## GG119 ROAD SAFETY AUDIT RESPONSE REPORT

| Project Title:         | Storthes Hall, Kirkburton  |
| Report Title:          | <b><u>Response Report to Stage 1 Road Safety Audit (rev 2)</u></b> |

This Road Safety Audit Response Report relates to a Stage 1 Road Safety Audit dated 27<sup>th</sup> February 2025 prepared by Road Safety Initiatives, which considers the proposed access arrangements and off-site highway works associated with a proposed residential development at the former Storthes Hall Student Village, Kirkburton, Huddersfield (Planning Application Reference 2023/93667). Full details of the scheme can be found within the Road Safety Audit Brief dated 14/02/25.

PROJECT STORTHES HALL, KIRKBURTON	CLIENT UBRIQUE INVESTMENTS LIMITED
DRAWING TITLE PROPOSED NORTHERN ACCESS ROAD LAYOUT	CHECKED MEW
	APPROVED MEW
	DRG No. 18092/GA/01
	DRAWN BY: JS
	SCALE @ A2 AS SHOWN
	DATE 10/03/2025
	REV. F

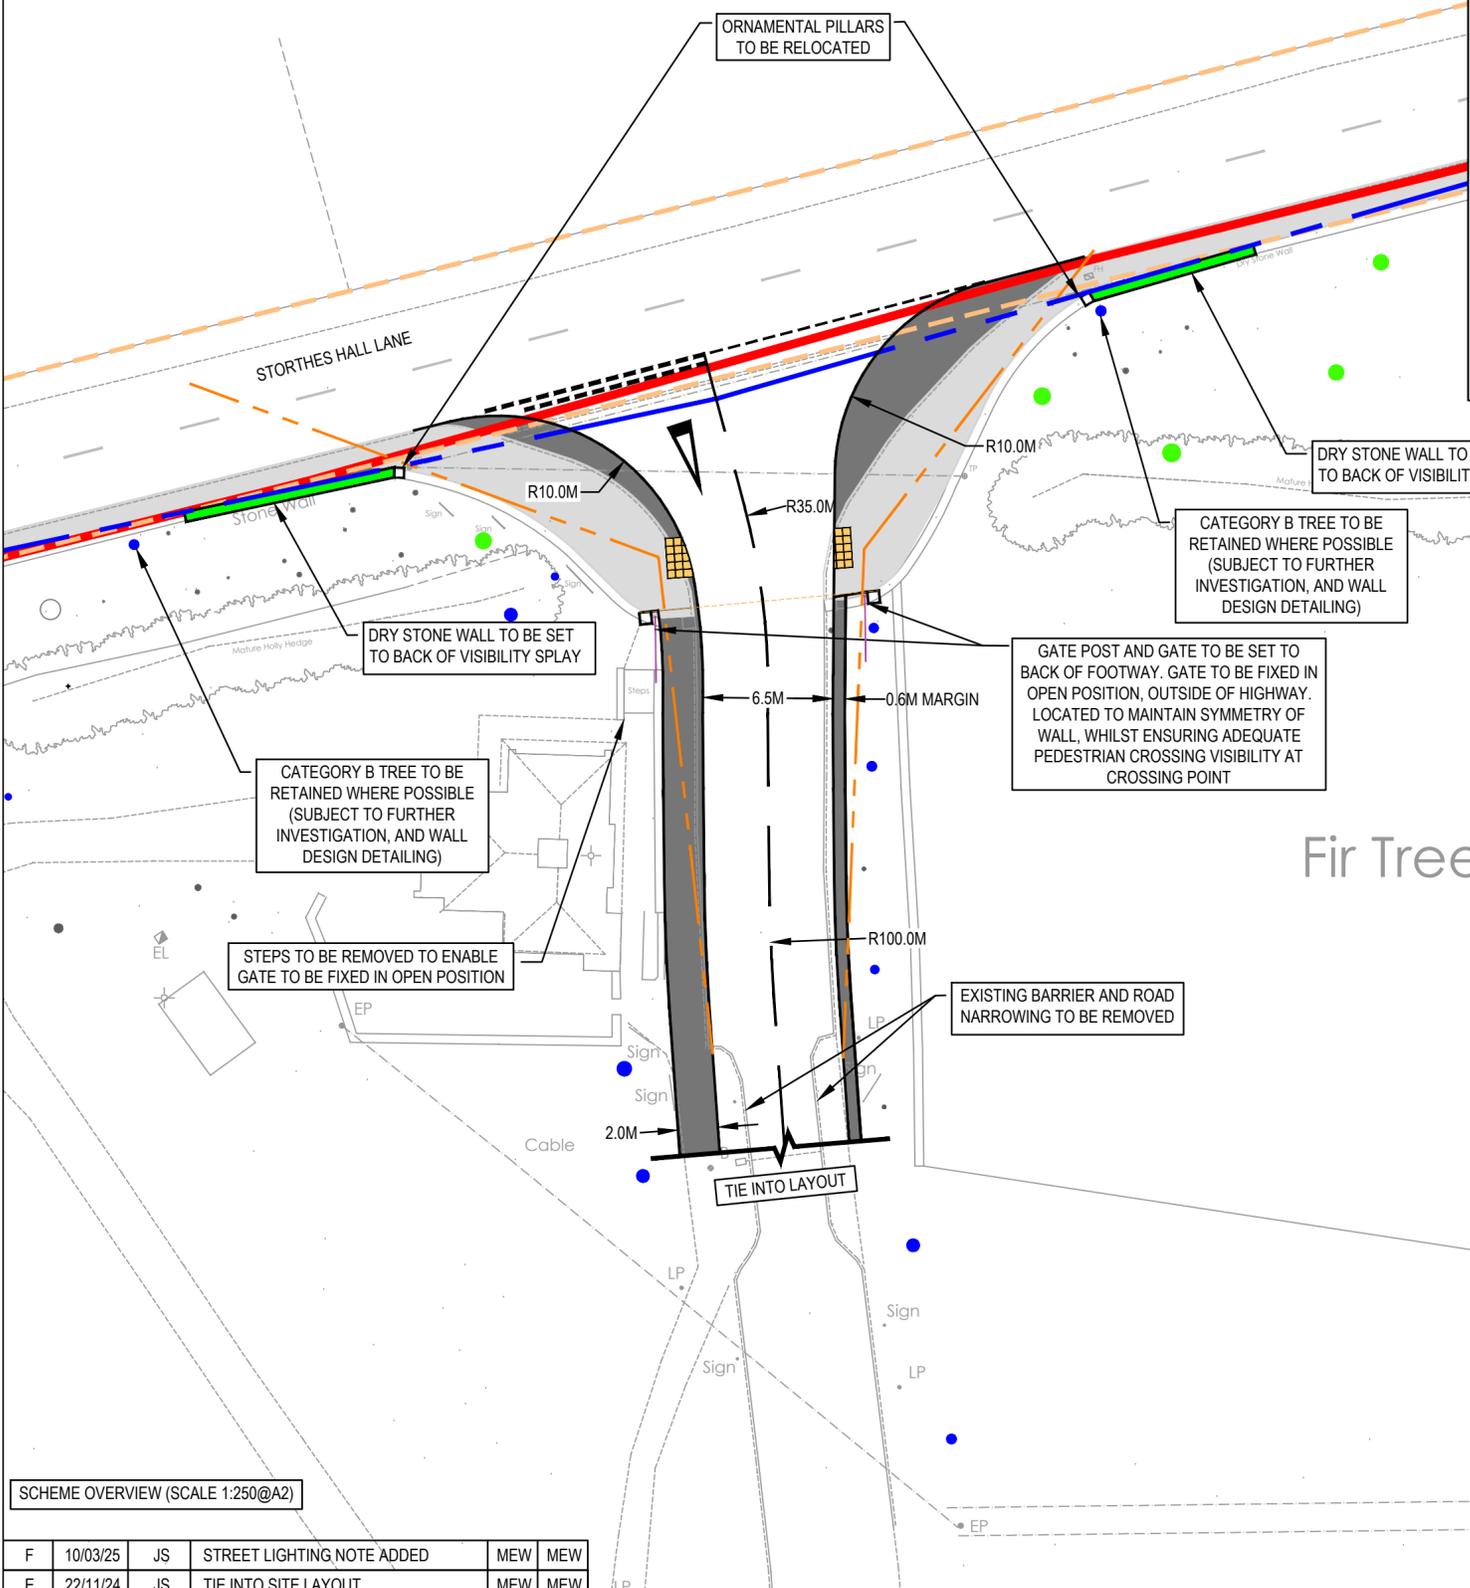
**Detail:** There will be an increase in pedestrian and cyclist activity as a result of the development. There is potential for a collision in darkness involving a vehicle and a pedestrian / cyclist crossing the junction.

**Recommendation:** It is recommended that adequate lighting is provided.

This has been noted on drawing 18092/GA/01 rev F (Note 4).

Note regarding street lighting added to drawing 18092/GA/01 Rev F.

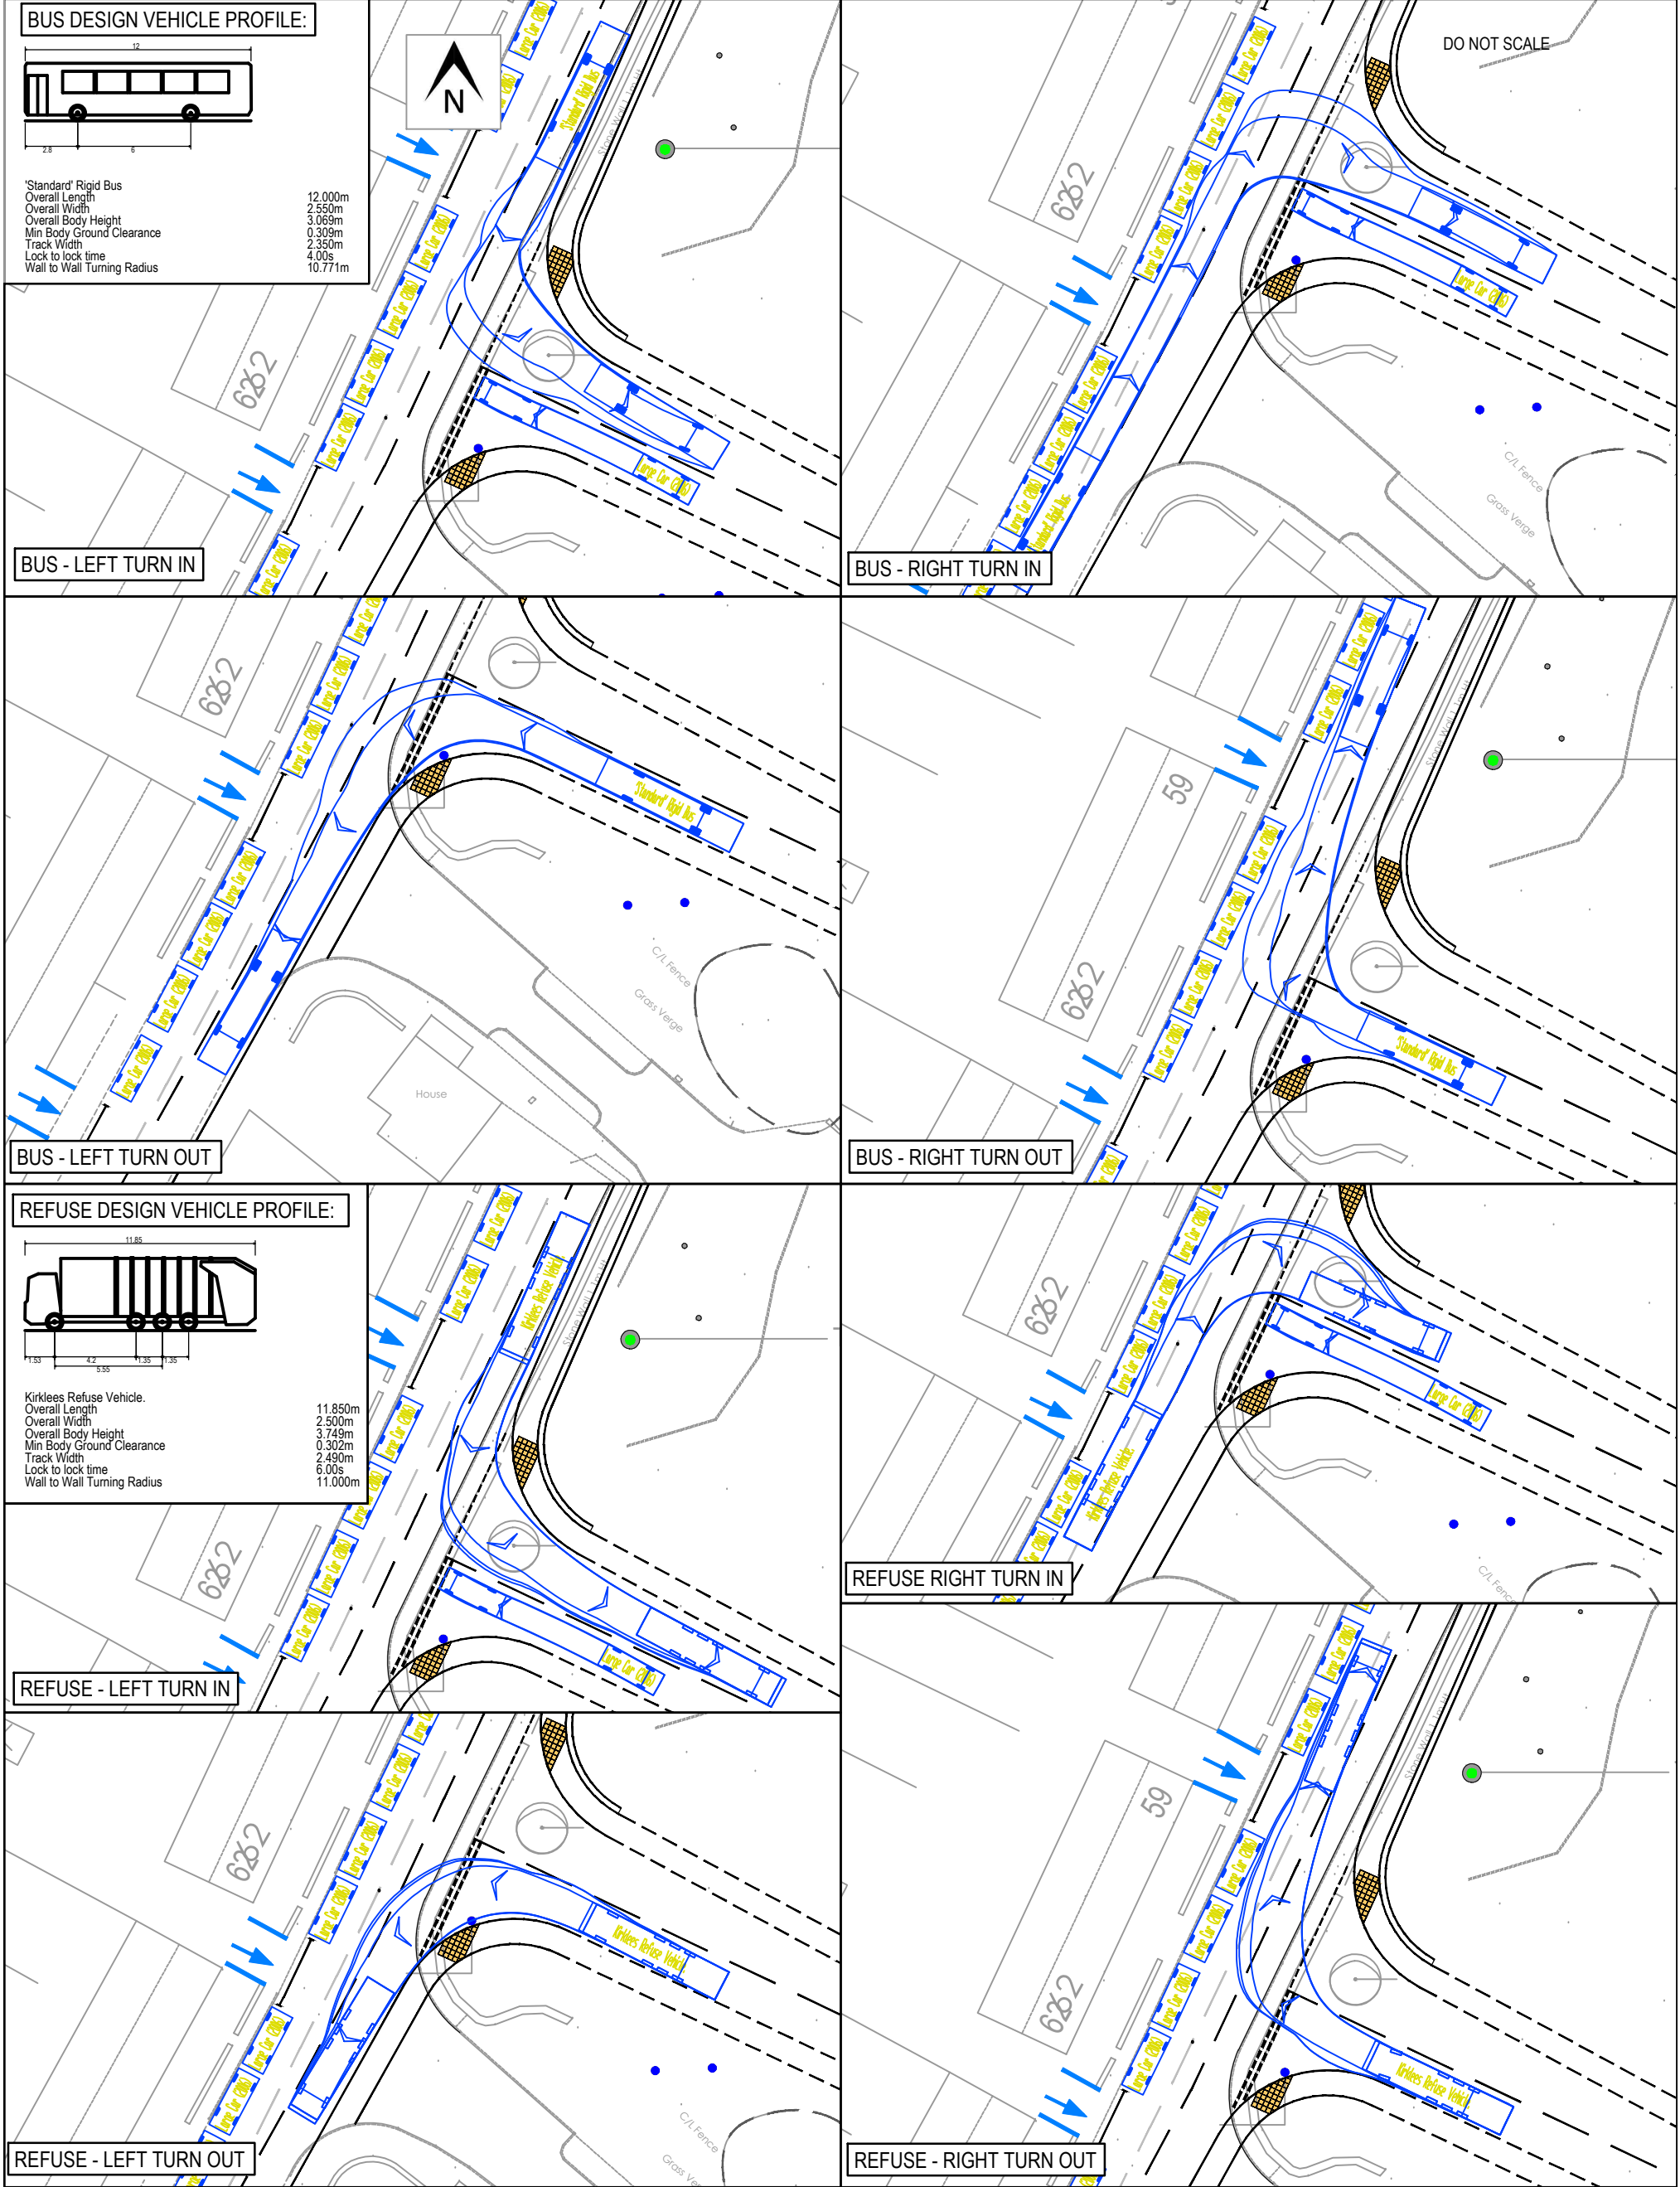
- Tracking drawing 18092/ATR/05 to be updated to include the position of parked cars on the west side of Storthes Hall Lane (e.g. in lieu of the of the parking bays markings that are to be removed from the drawing – see above).

A vehicle swept path analysis of the road widening option are shown on drawing no. 18092/ATR/05.

Road widening scheme proposed. The requested minor amendments are shown on updated drawing 18092/GA/06 Rev B with revised tracking shown on drawing 18092/ATR/05 Rev B.

| PROJECT                                                               |  |  |  |  |  | CLIENT                      |          |             |      |
|-----------------------------------------------------------------------|--|--|--|--|--|-----------------------------|----------|-------------|------|
| PROPOSED SOUTHERN ACCESS ROAD LAYOUT - INCLUDING CARRIAGEWAY WIDENING |  |  |  |  |  | MEW                         | MEW      | 18092/GA/06 |      |

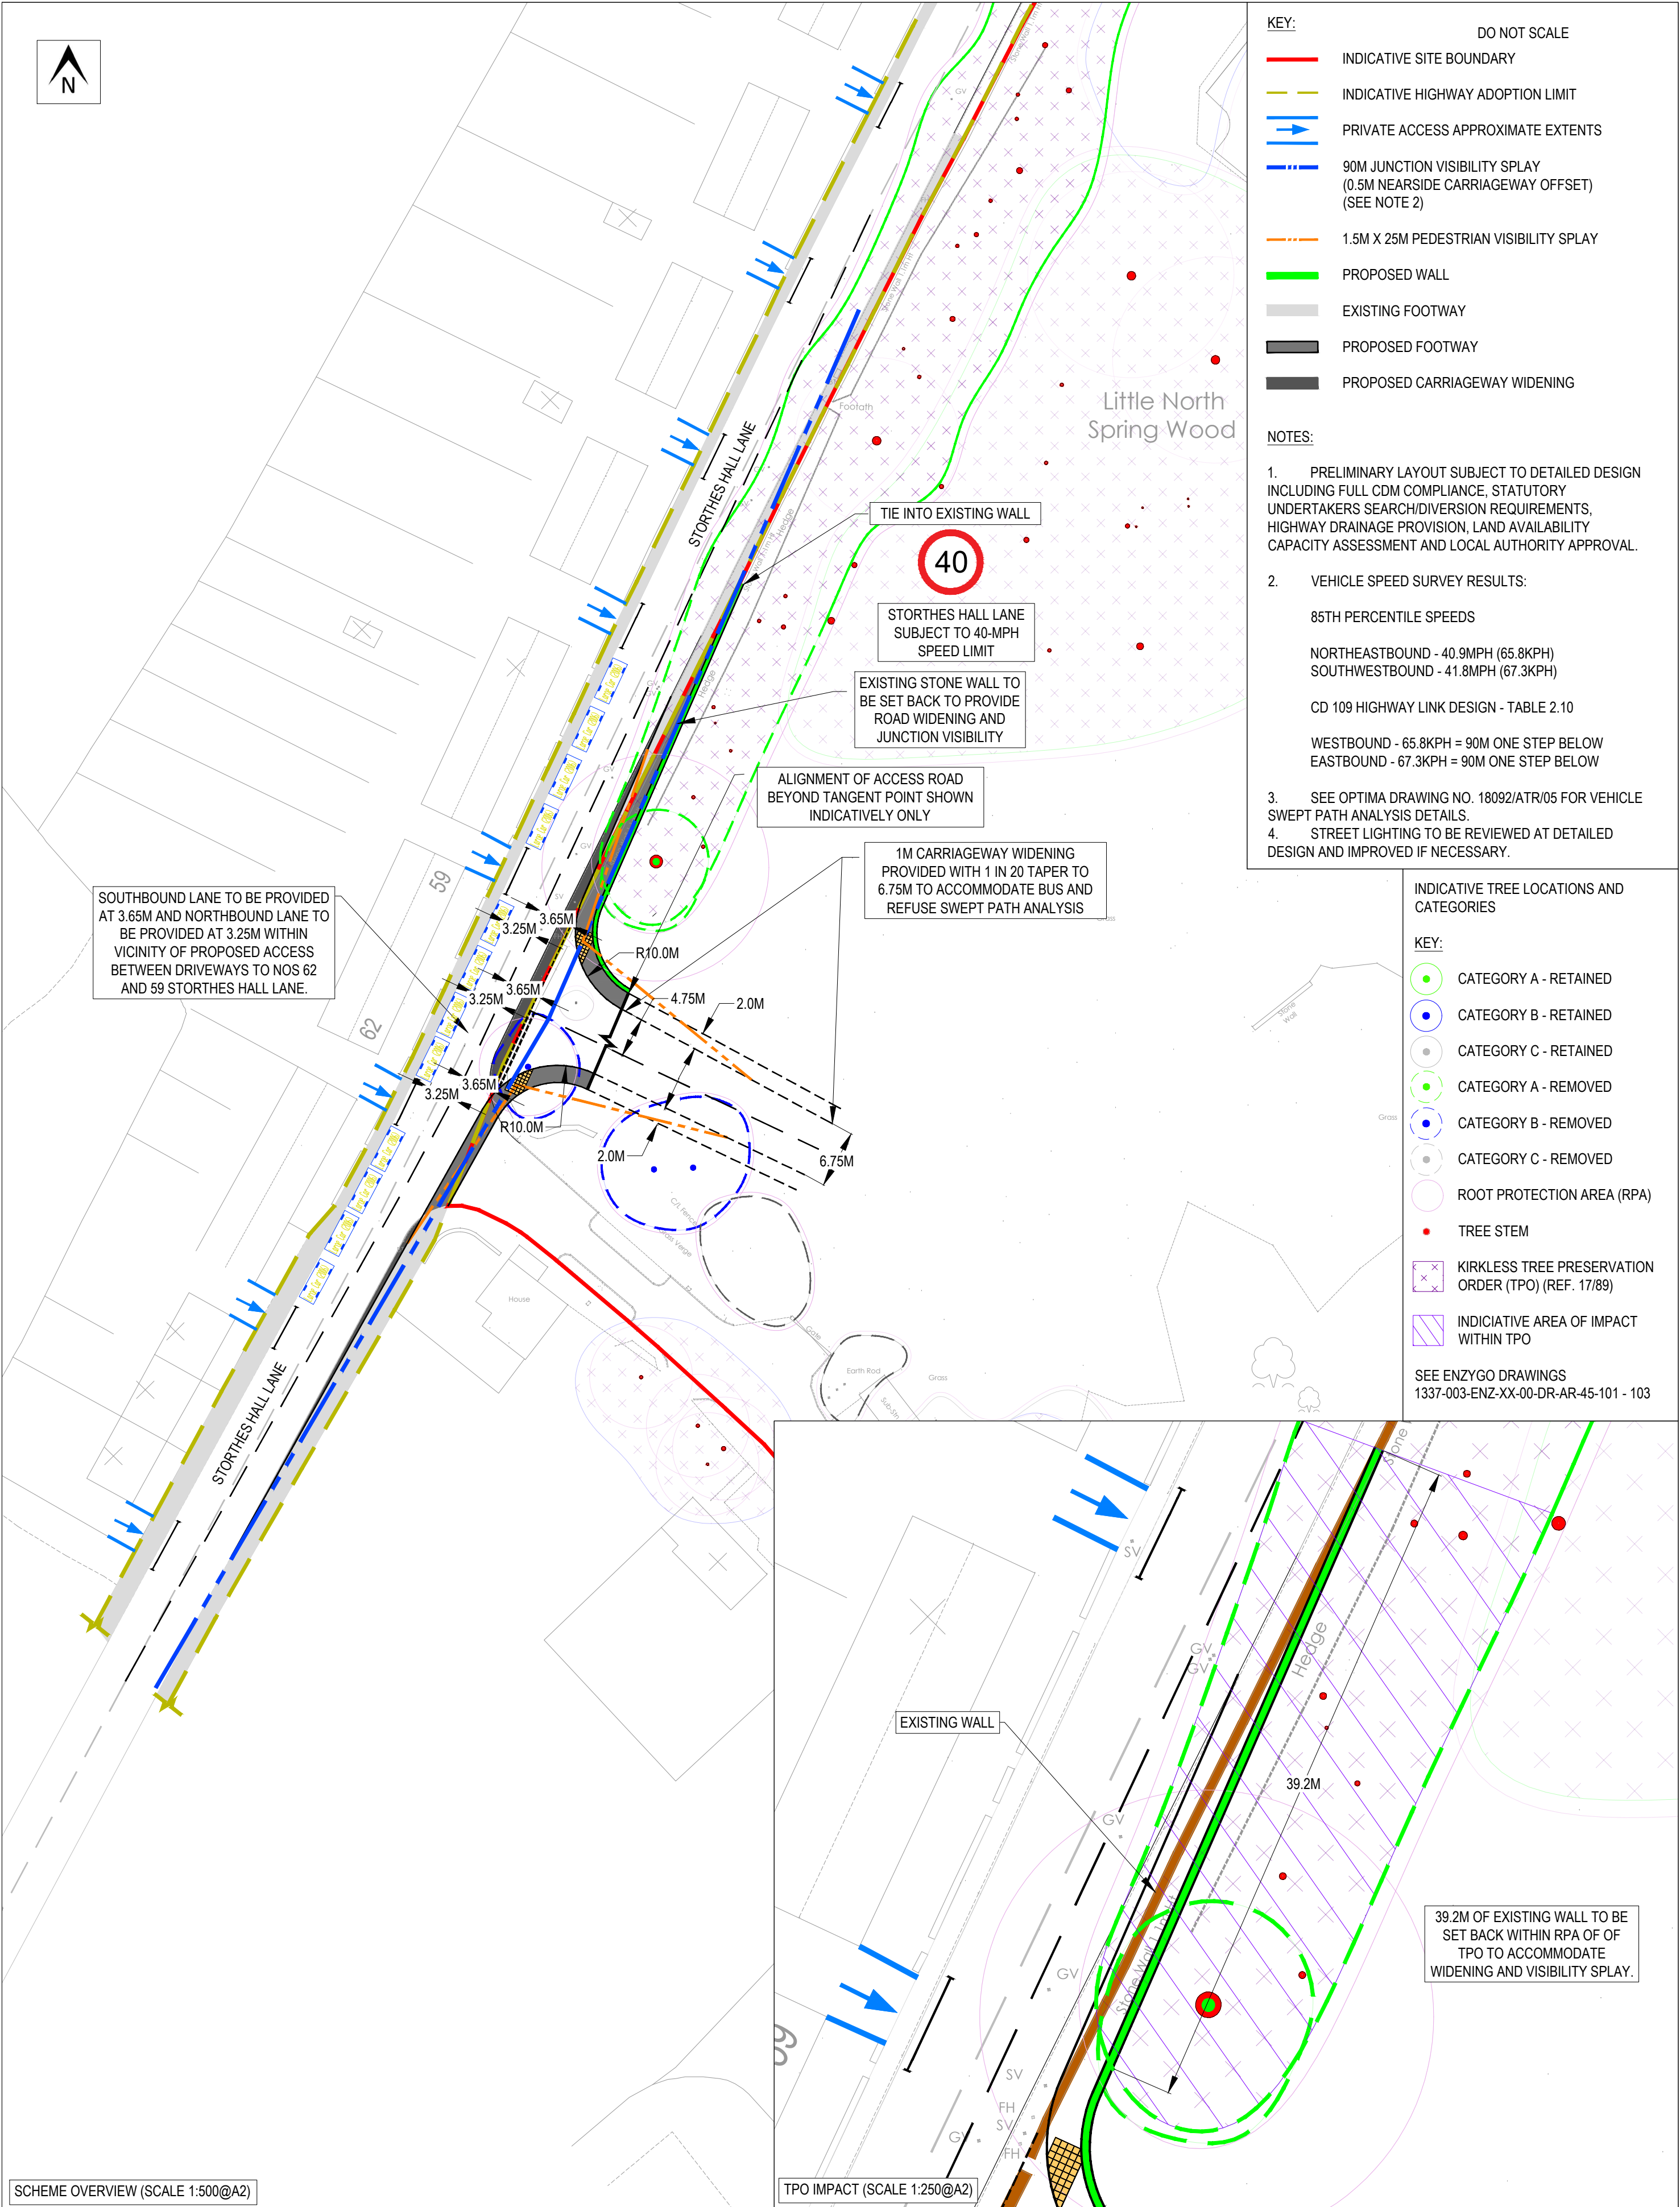
**Detail:** On-street parking directly opposite the access junction (the access road will become two-way) may result in a vehicle turning right into the junction blocking through traffic. This may lead to possible 'shunts' or 'head-on' related collisions.

**Recommendation:** It is recommended that Storthes Hall lane is widened to allow unimpeded two-way movements, with on-street parking still present. If this is not practical, its recommended that parking restrictions are introduced or that the access junction is relocated away from on-street parking.

- The parking bay markings shown on the west side of Storthes Hall Lane are considered to provide little (if any) benefit. Therefore, these should be omitted. In their place, keep clear line markings (with no text) to diagram 1026.1 of TSRGD should be installed at the private drives on the west side of Storthes Hall Lane instead.

- Additional dimensions to be added to drawing 18092/GA/06. These should confirm the southbound lane width is to be narrowed to a consistent minimum width of 3.65m (e.g. between the drives to No. 62 and 59), and that the northbound traffic lane will be locally widened to 3.25m within the vicinity of the access (e.g. again, between the drives of No. 62 and 59).

**Detail:** On-street parking directly opposite the access junction (the access road will become two-way) may result in a vehicle turning right out of the junction travelling on the wrong side of the road to pass parked vehicles. This may lead to possible 'head-on' related collisions.

**Recommendation:** It is recommended that Storthes Hall lane is widened to allow unimpeded two-way movements, with on-street parking still present. If this is not practical, its recommended that parking restrictions are introduced or that the access junction is relocated away from on-street parking.

**Recommendation:** It is recommended that adequate lighting is provided.

An alternative design has also been produced shown on drawing no. 18092/GA/06, which illustrates proposed road widening along Storthes Hall Lane to allow the existing on street parking to remain in situ.

In order to accommodate minimum through lane widths, the junction location would be required to relocate further north. The proposed carriageway widening and visibility splays require the boundary wall along Storthes Hall Lane to be set back into the root protection area of trees subject to a tree preservation by up to 1.8m over a length of circa 39m, resulting in additional tree loss.

An alternative design has also been produced shown on drawing no. 18092/GA/06, which illustrates proposed road widening along Storthes Hall Lane to allow the existing on street parking to remain in situ.

This has been noted on drawings 18092/GA/02 rev G and 18092/GA/06 (Note 4).

Note regarding street lighting added to drawing 18092/GA/06 Rev B.
